Application Reference Number:		2026/0139	
Application Type:		Householder	
Proposal Description:		Removal of existing single storey rear extension and detached single garage, and erection of front and rear extensions, raising of roof to enable loft conversion, and install balcony to rear of dwelling	
Location:		44 Bar Lane, Staincross, Barnsley, S75 6DF	
Applicant:		Mr Ryan Holmes	
Third-party representations:	None	Parish:	None
		Ward:	Darton East

This planning application seeks householder planning permission for the removal of the existing single storey rear extension and detached garage, and the erection of front and rear extensions, as well as the raising of the dwelling's roof to enable a loft conversion and the installation of a balcony to the rear of dwelling.

TITLE
LOFT CONVERSION
PROPOSED ELEVATIONS

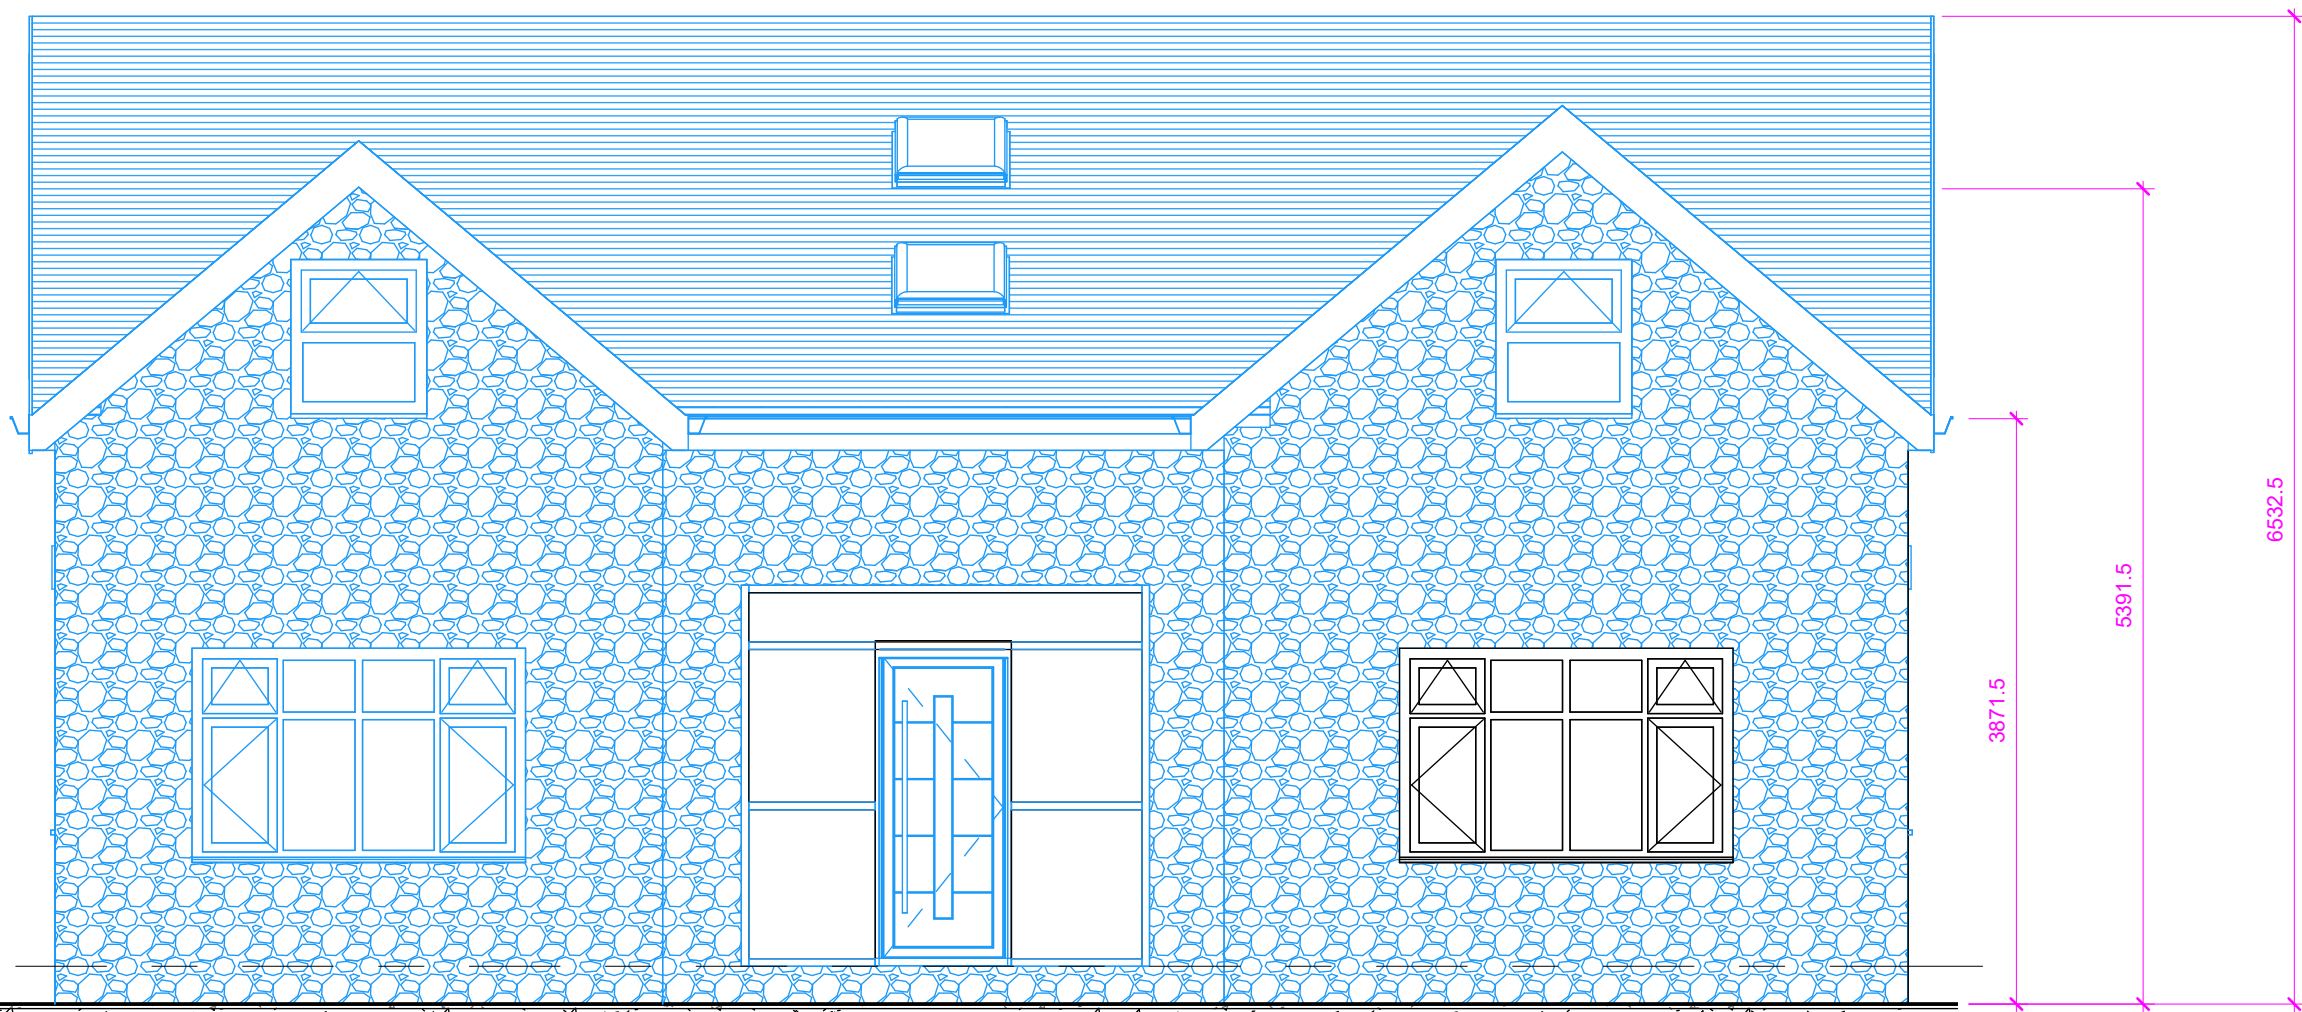
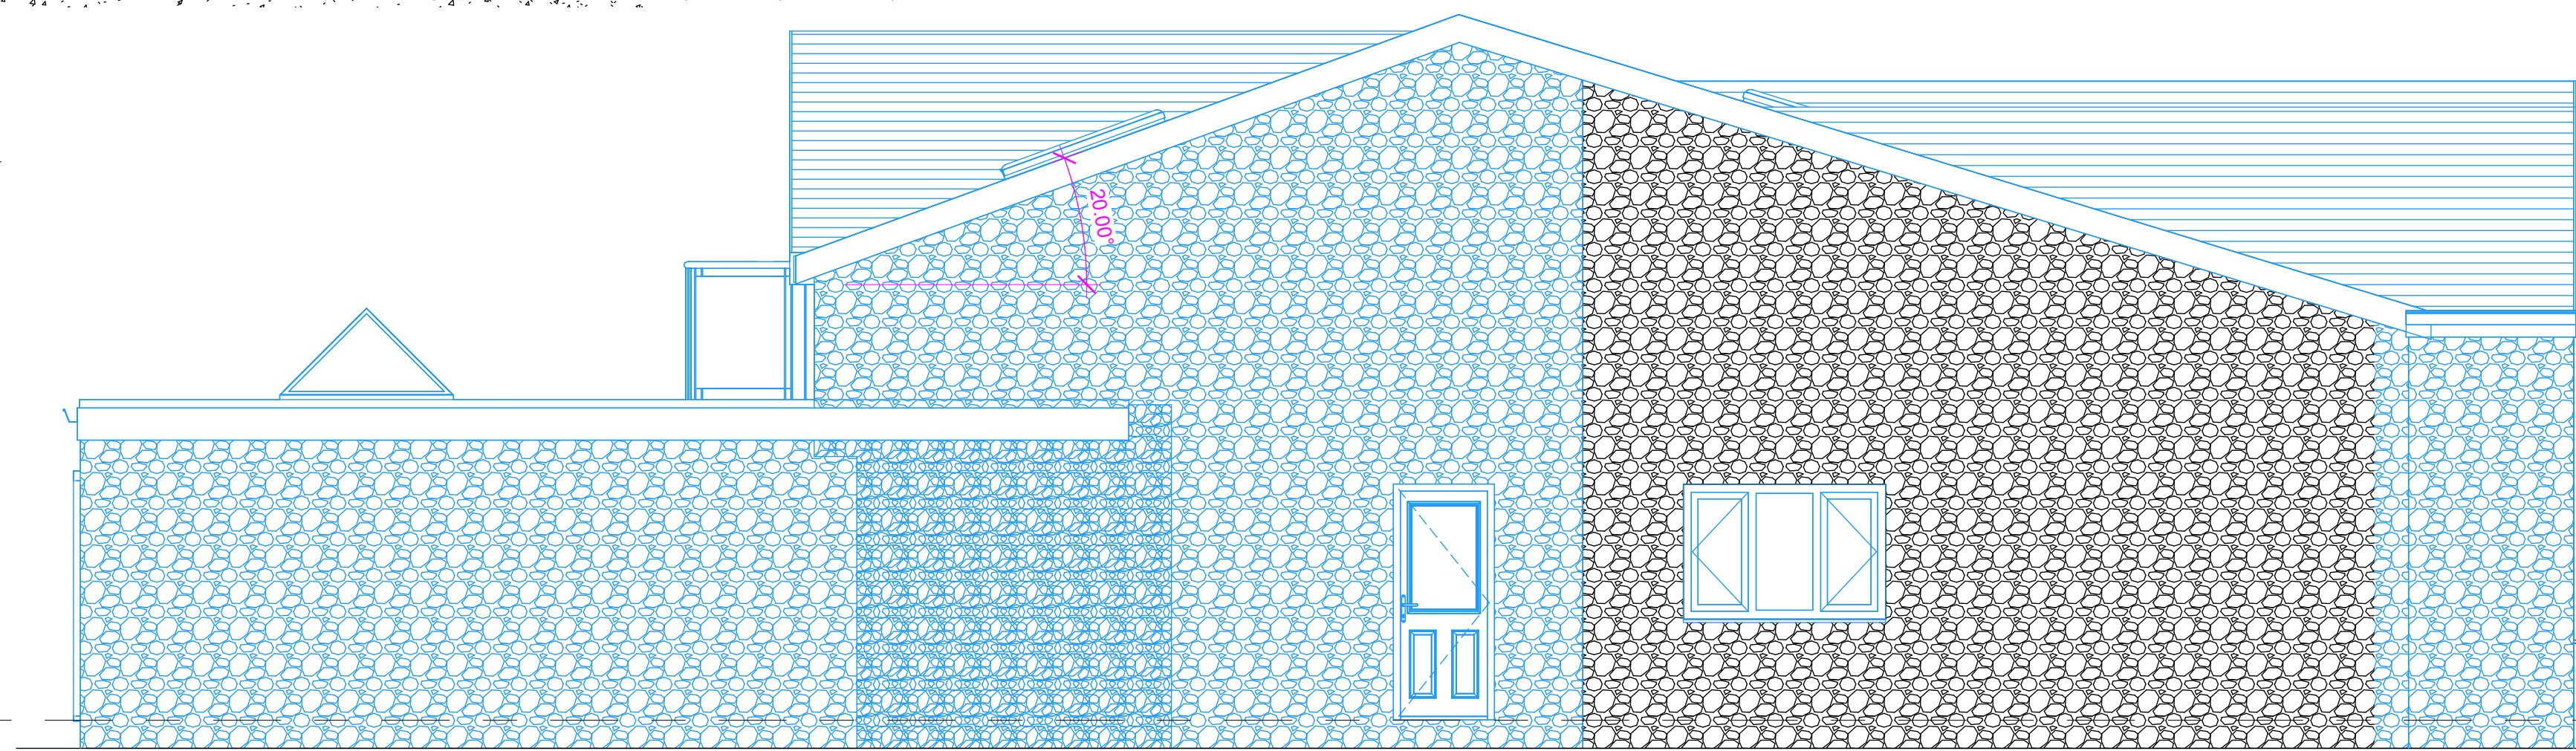
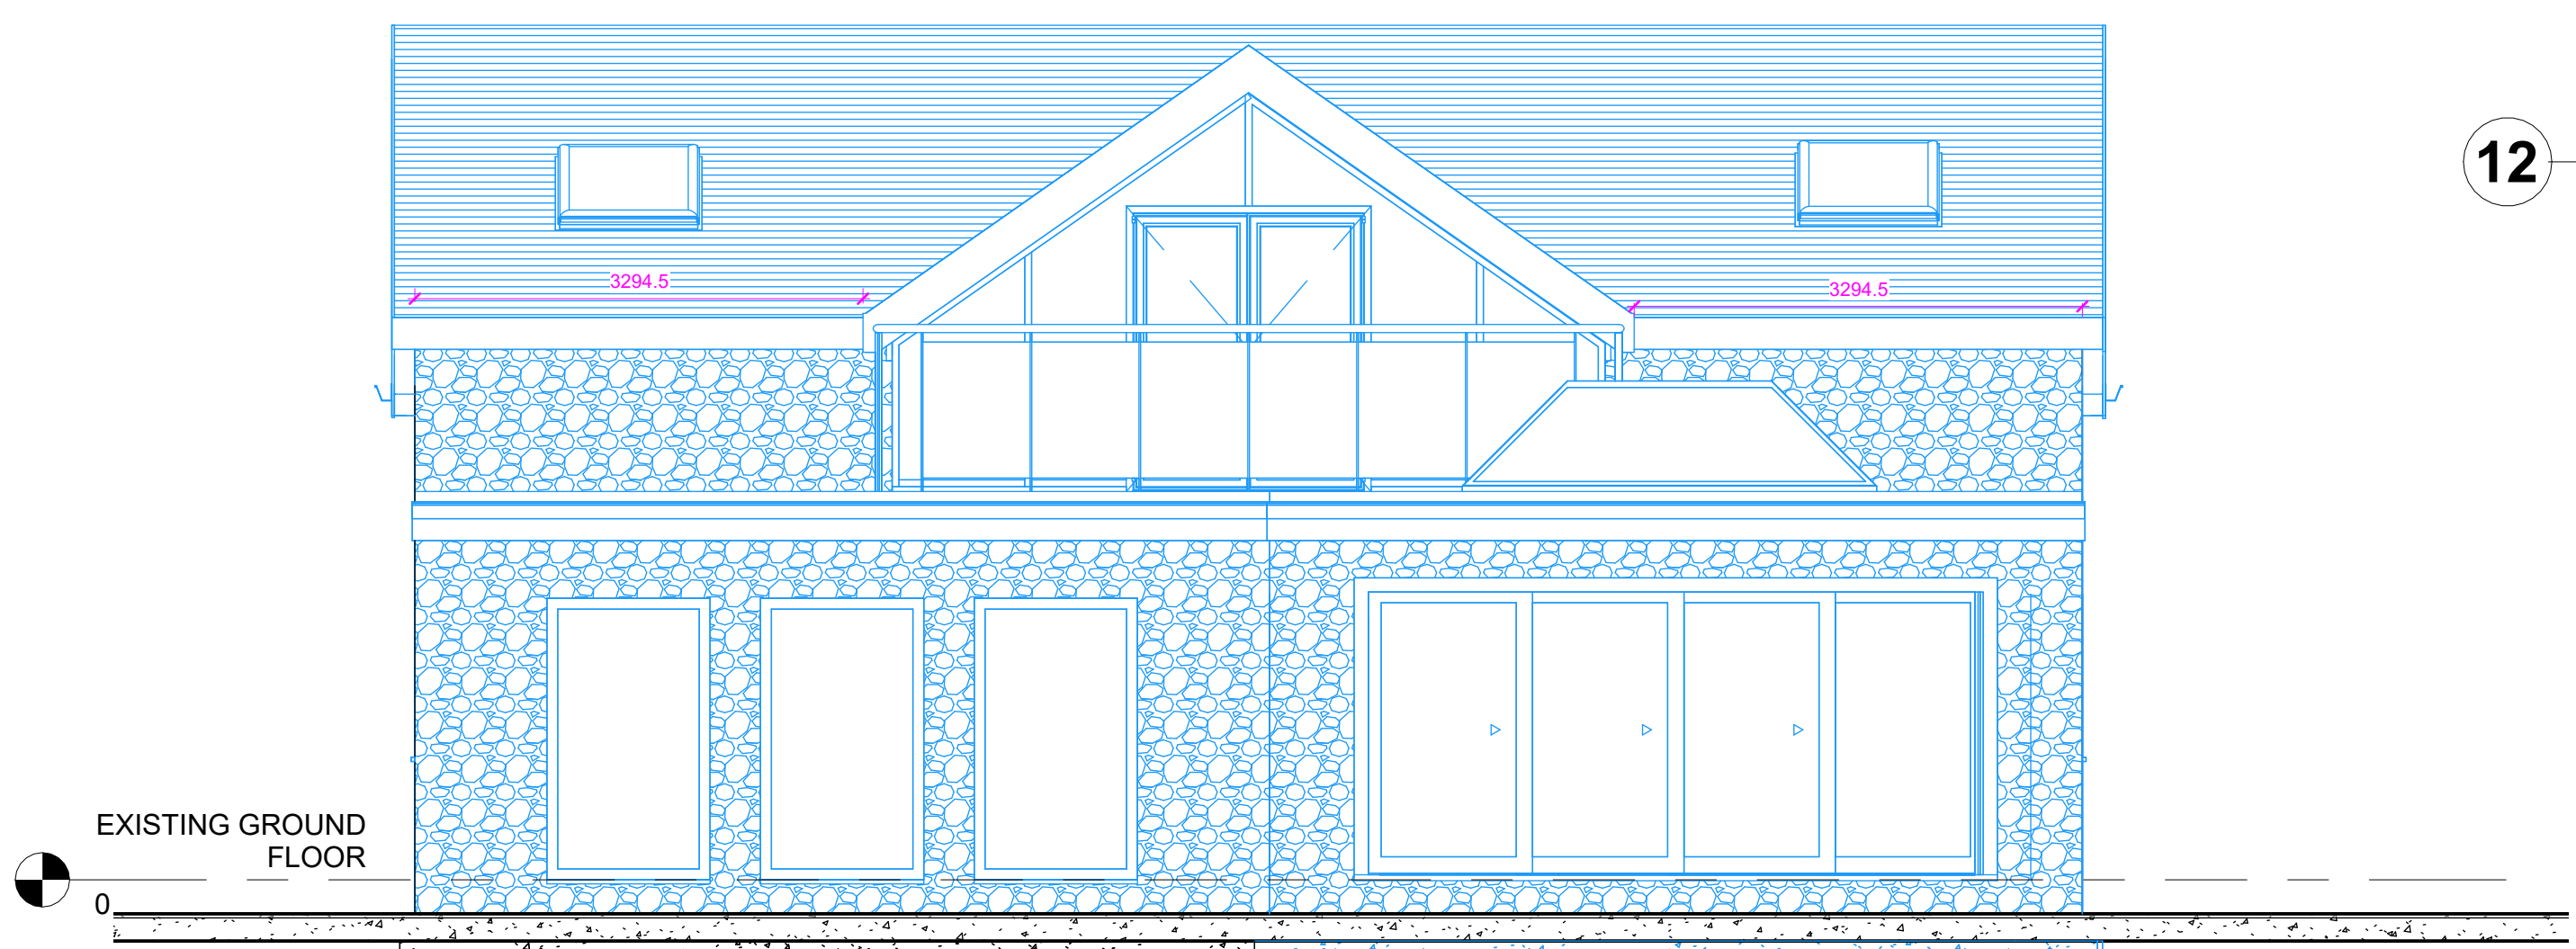
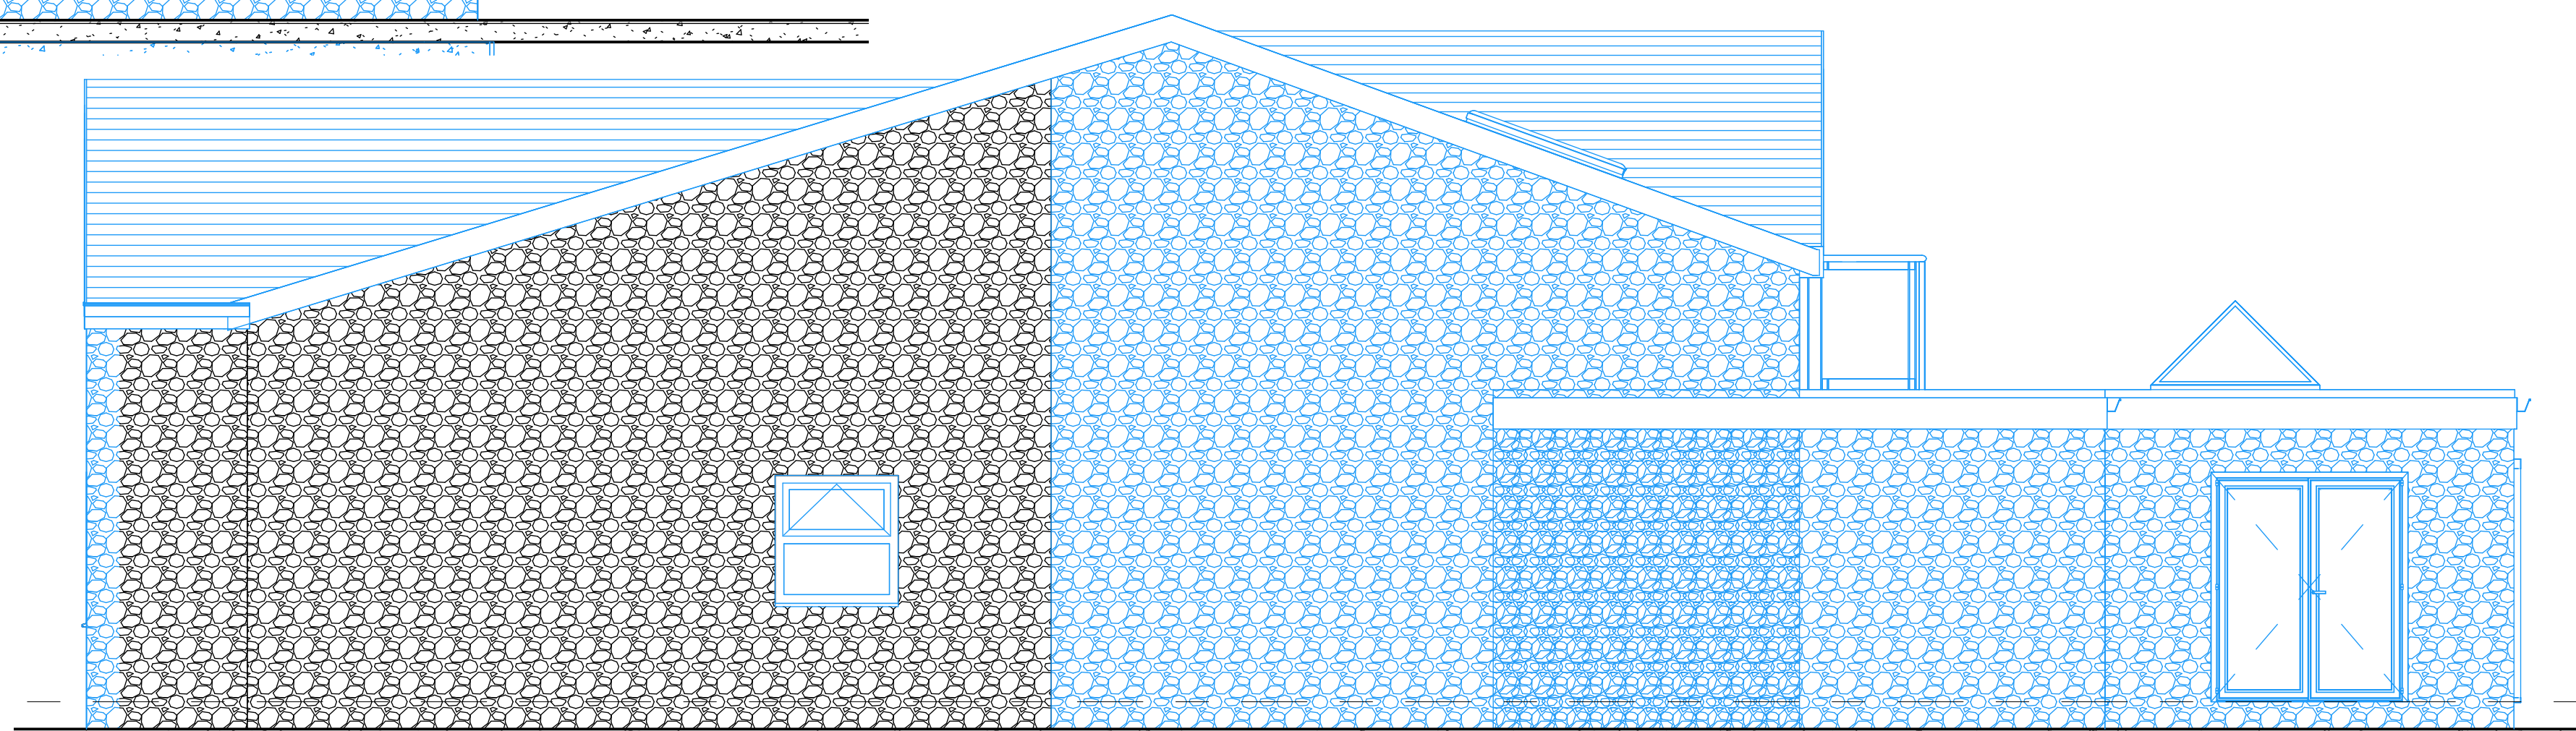
Balconies can cause significant overlooking into the private amenity space of neighbouring dwellings however, the proposed inset balcony features two privacy screens that restrict viewing from the balcony to the centre of the dwelling looking out onto the rear garden of the host dwelling. There are no dwellings to the rear and beyond the rear garden is Green Belt land. As such, there is unlikely to be any detrimental levels of overlooking onto neighbouring dwellings from the proposed balcony. This weighs significantly in favour of the proposal. The proposal is considered to be in compliance with Local Plan Policy GD1: General Development and is acceptable in terms of residential amenity.

The SPD states *that 'materials should normally be of the same type, colour and texture to the existing house or as close a match as possible'*. In this case, the proposed materials will not match the existing dwelling as stone is proposed to the front elevation which is a change from the existing redbrick. This change in materials will not be significantly harmful to the character of the street scene however as a mix of materials is present in the vicinity of the dwelling including, redbrick, stone and render. Additionally, the dwelling is not set within a run of redbrick properties as the property to the east (42 Bar Lane) is constructed of render. Furthermore, the rest of the elevations are to be off-white render which again given the adjacent property is also rendered this is therefore acceptable. This weighs significantly in favour of the proposal.

The proposal includes a change in roof type from a hipped roof to a pitched roof. Of the adjacent neighbouring dwellings only one other utilises a hipped roof (46 Bar Lane) with the rest featuring pitched roofs. Furthermore, due to the differing dwelling sizes there is little symmetry between the two existing hipped roofs apart from them both being hipped. There are examples of pitched roofed dwellings in the street scene and in close proximity of the host dwelling, therefore due to the mixed street scene the change would not be significantly detrimental to the visual amenities of Bar Lane. This weighs significantly in favour of the proposal.

Furthermore, the proposal also includes the raising of the dwelling's roof height by 1.15 metres. Other two storey dwellings are present on Bar Lane and one of the adjacent neighbouring dwellings (46 Bar Lane) whilst still a bungalow has a taller ridge height the existing dwelling. The increase in height of the dwelling would not be significantly impactful upon the character of the street scene. This weighs significantly in favour of the proposal.

The single storey rear extension utilises a flat roof which is usually not a supported roof type due to flat roofs being an inferior form of construction. However, in this circumstance it is considered acceptable due to being set to the rear of the dwelling, away from public vantage points and therefore the extension won't be highly prominent in the street scene. This weighs significantly in favour of the proposal. The proposed development is therefore not considered to be contrary to Local Plan Policy D1: High Quality Design and Place Making and is considered acceptable in terms of visual amenity.
